CITY OF ALBUQUERQUE

November 19, 2019

RE: **Albuquerque School of Excellence Expansion**
13201 Lomas NE
Grading and Drainage Plan Stamp Date: 11/7/19
Hydrology File: J22D050

<b>ABQ SCHOOL OF EXCELLENCE</b> <b>GRADING AND DRAINAGE PLAN</b>	DRAWN BY pm DATE 11-5-19 DRAWING 2019068-GR
	TIERRA WEST, LLC 5571 MIDWAY PARK PL NE ALBUQUERQUE, NEW MEXICO 87109 (505) 858-3100 www.tierrawestllc.com	SHEET # <b>GR-2</b> JOB # 2019068

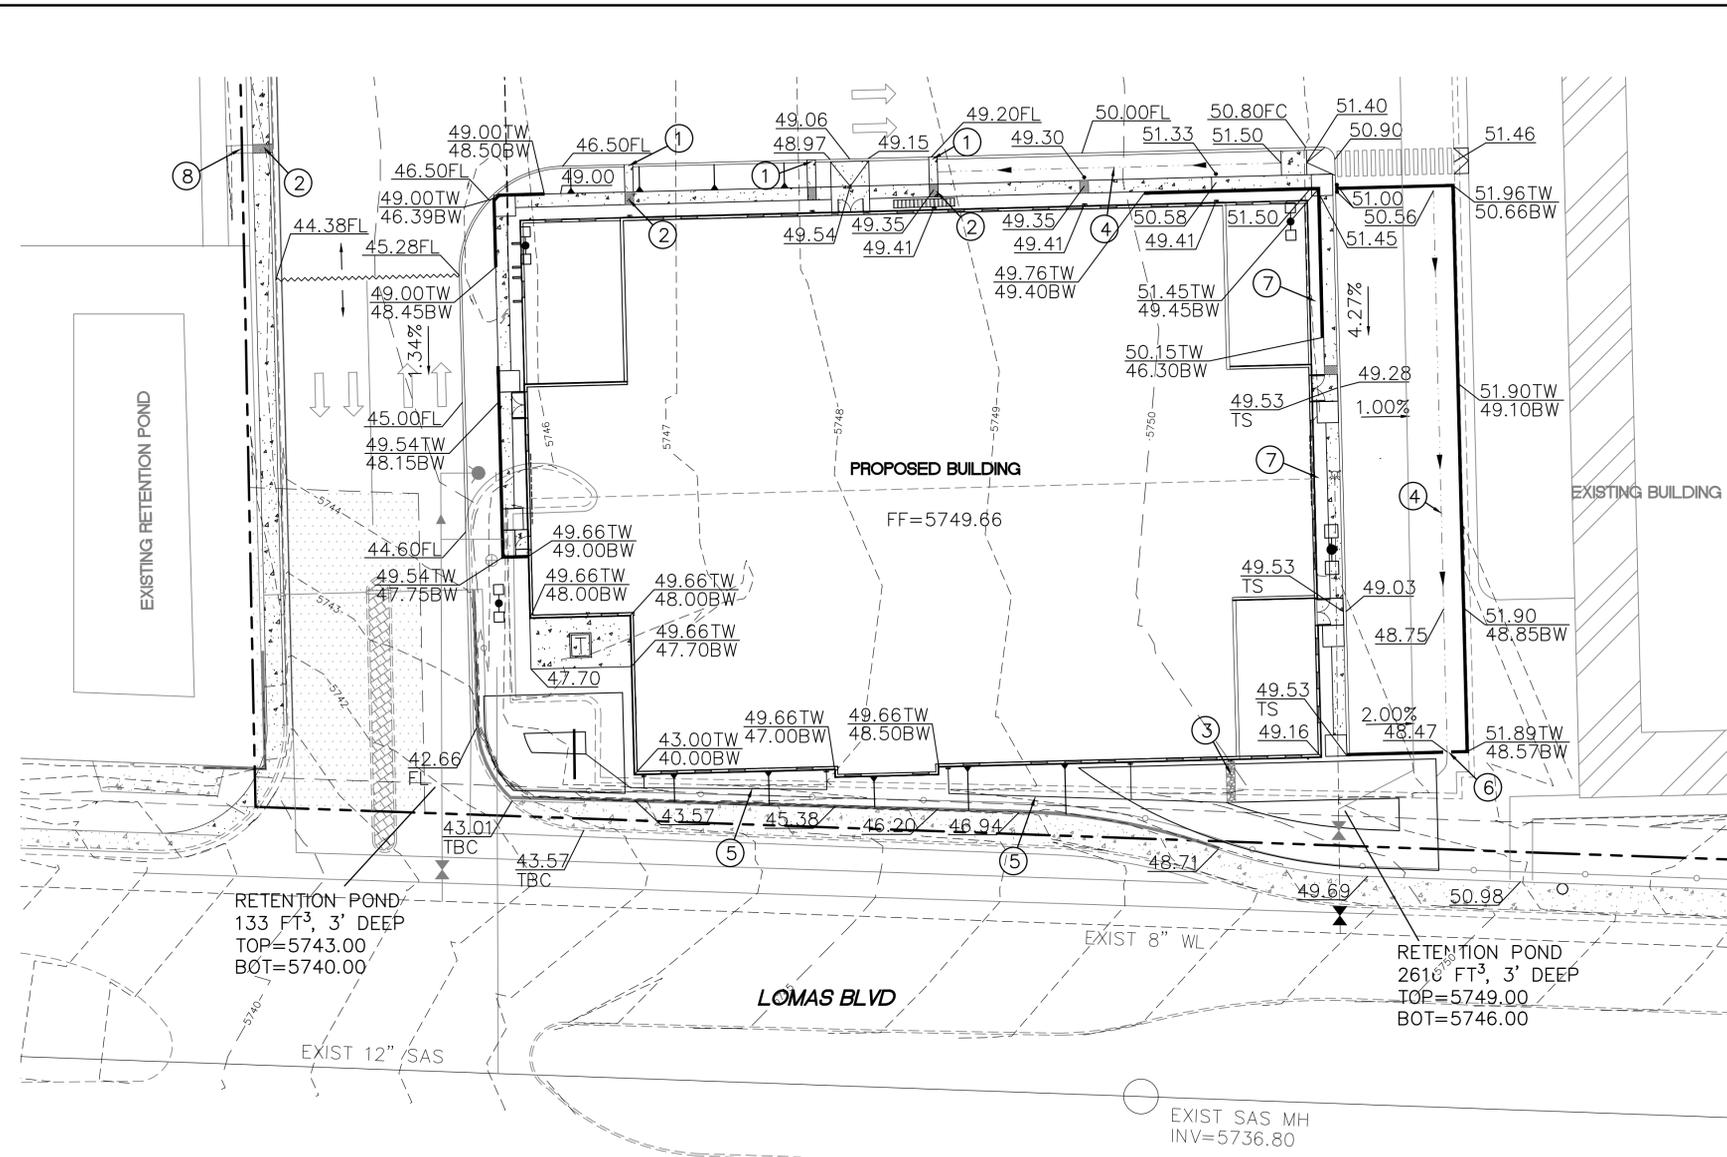
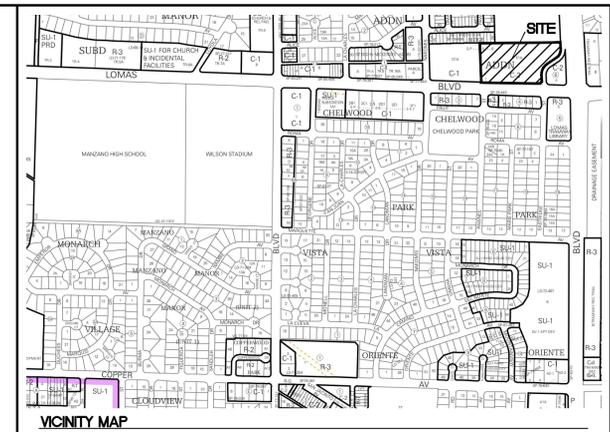
1. Please number the ponds and include sections and labels on each with the Stormwater Quality Volume (SWQV) and elevation, the 100-year volume and elevation, the peak 100 year inflow, top of pond elevation. Provide pond volume calculations by contour area; correct the volume on the western pond.

2. Please include the SWQV calculations. This site qualifies as redevelopment and is only required to retain runoff from the 80th percentile storm ($\text{Vol.} = 0.26'' * \text{Imp. Area}$).

3. The eastern (and western) pond cannot encroach on the ROW.
4. Provide a section through the proposed building and Lomas. Provide stabilization of slopes exceeding 3:1. There's one stem wall elevation called out as $\text{TW} = 43.00$ that probably should be 49.66.
